DOC20/321091

27 April 2020

**Fort Street Public School (SSD 10340)
Advice on the Environmental Impact Statement (EIS)**

Figure 6: Acoustic screen around chillers

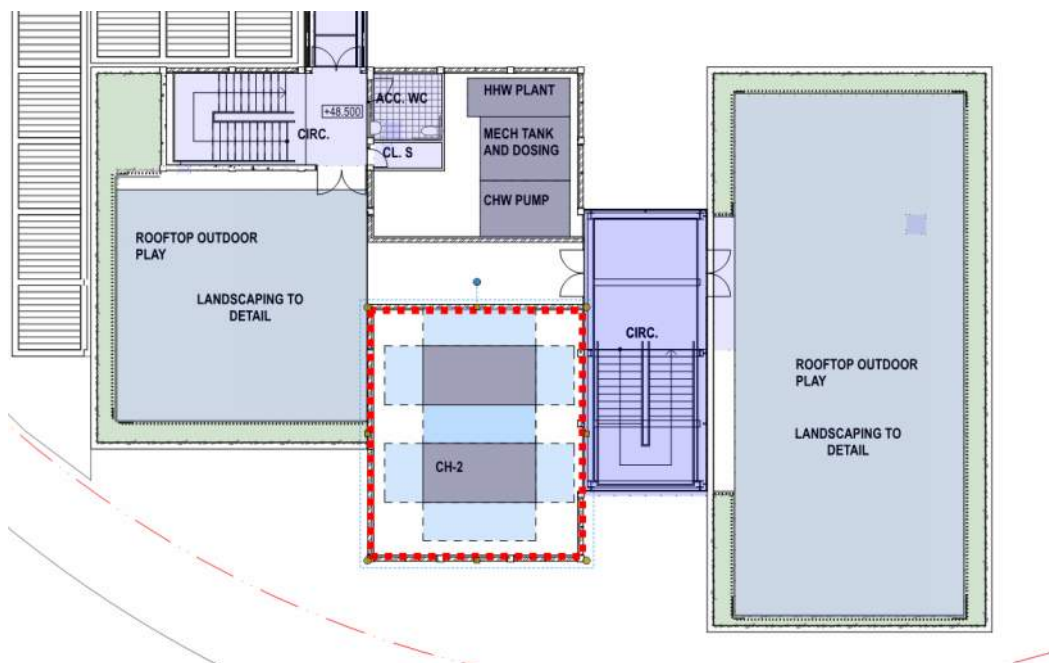
The main source of operational noise will be from mechanical services, including chillers, fans and pumps. The acoustic assessment has only considered noise from chillers as a reasonable worst-case noise source and assessed this in accordance with the *Noise Policy for Industry* (EPA, 2017) for day and evening periods only. Because it is anticipated that mechanical services plant may also be operational during the night, it is recommended that all mechanical services plant be designed to achieve 50 dB $L_{Aeq15min}$ at the closest noise sensitive receiver/s. This is based on the project noise trigger level for the night-period of 45 dB $L_{Aeq15min}$ + 5 dB (refer Table 7 of the *Acoustic Assessment*).
